## City of Albuquerque

January 19, 1983

RE: REGINA HALL DRAINAGE PLAN

SECTION E-E

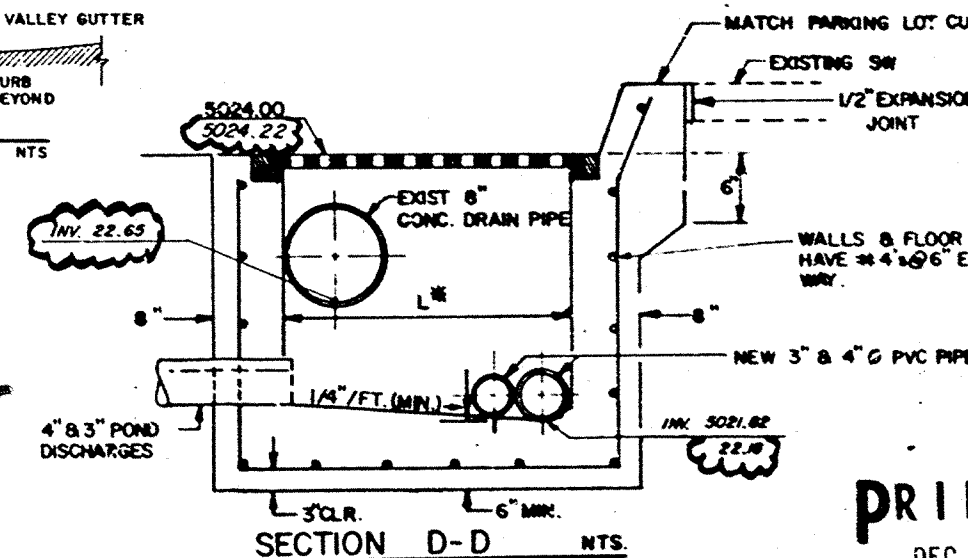
2. Will gravel or some other means be used to prevent irrigation runoff from leaving the site?
3. Does Section E-E reflect the criteria that the driveway elevation at the property line should be one-foot above the street flowline (Item K, p.109 of the DPM).

APPROVALS	ENGINEER	DATE	TITLE	
A.C.E. / DESIGN			REGINA HALL DRAINAGE PLAN	
INSPECTOR			PLAN - SW CORNER PARKING LOT	
A.C.E. / FIELD			PROJECT	MAP
			NO. 2 OF 4	NO.

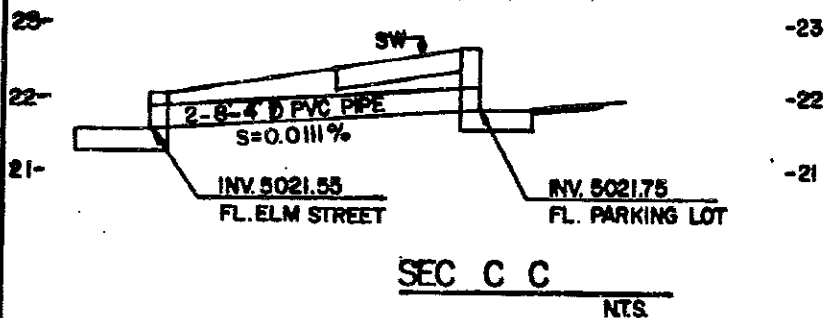
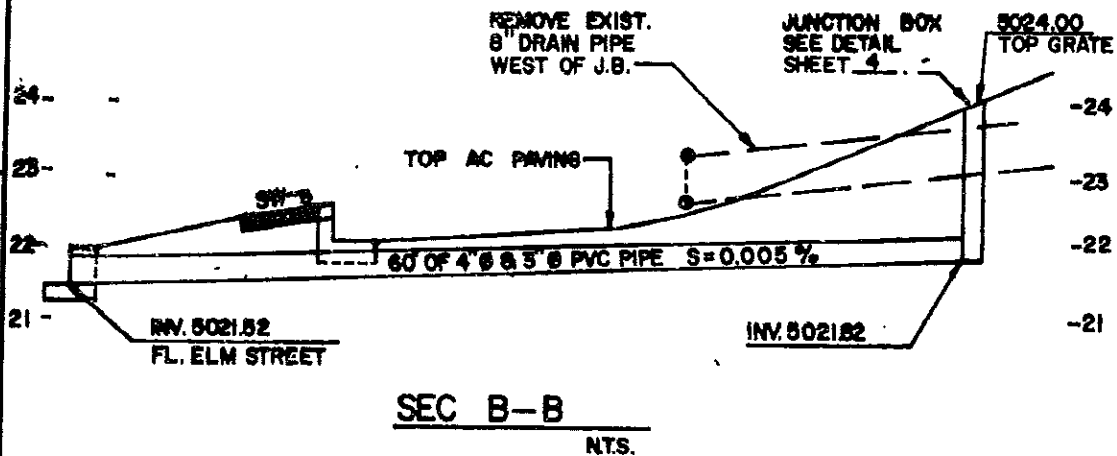
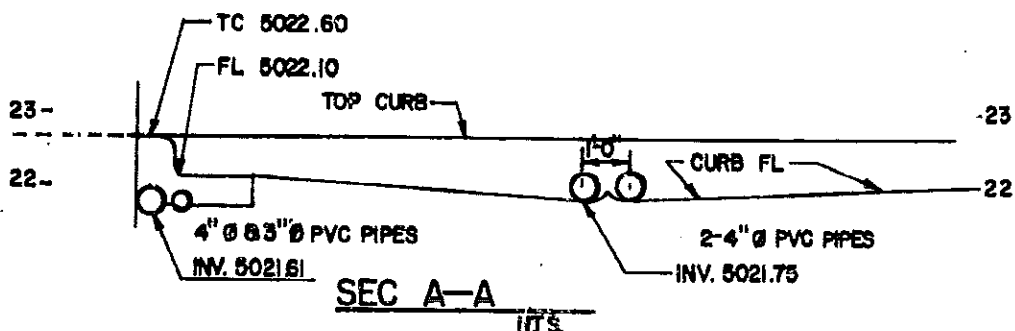
5. On page 4 of the report it states "that the driveway has a slight swale to channel drainage to the southwest corner until it is full at which time the water will flow out through the driveway." Please include elevations at the driveway indicating that this will be the case.
